DA Access Report

*Teloopa Estate – Stage 1A
Lot 5-7 of Masterplan,
Teloopa NSW 2026*

Prepared for
Fraser's Property Australia

30 May 2023

DRAWING TITLE BASEMENT 01 PLAN
SCALE 1:300 @A1
DATE 17/02/2020
DRAWN AH
CHECKED RP
JOB NO. 20320
DRAWING NO. PLA-AR-DA0098

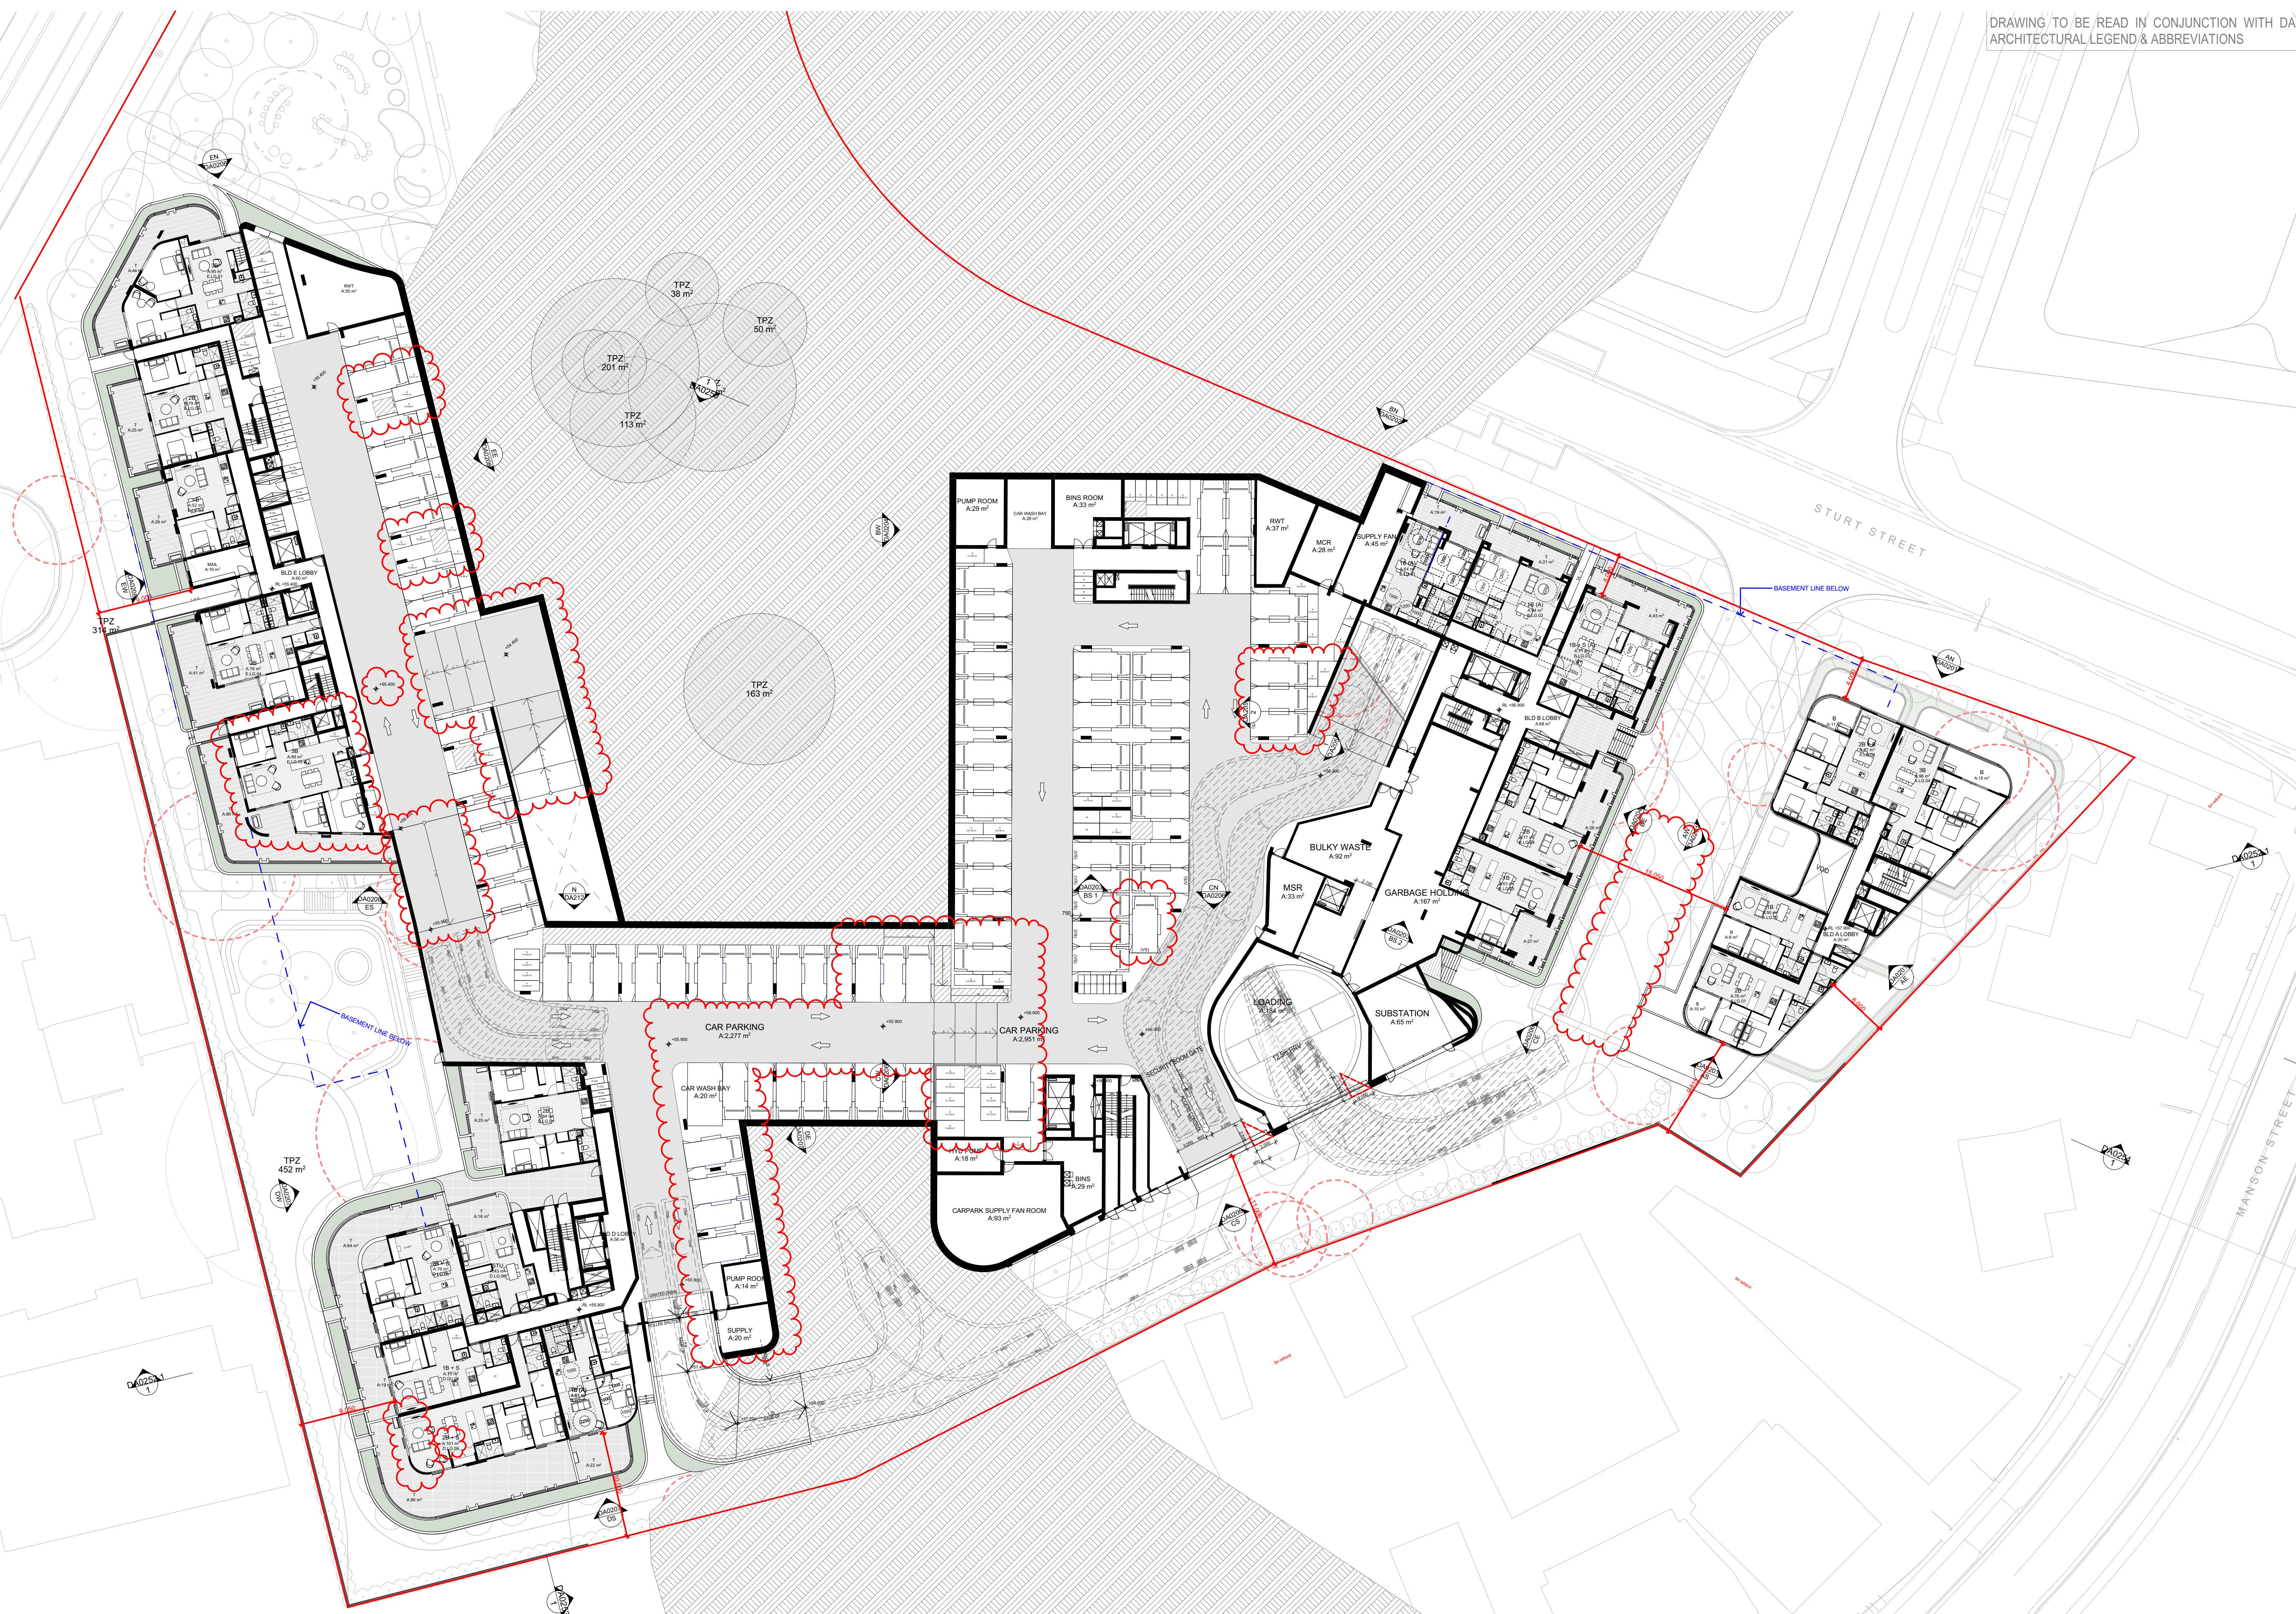
Within the residential building, there is suitable access within residential corridors to all sole-occupancy units located within the building. Corridors generally achieve minimum 1600mm clear widths with appropriate wheelchair turning areas located within the ends of corridors. Review is required of the end of corridor clearance in Building A, on Basement 01 which has 1200mm clearance.
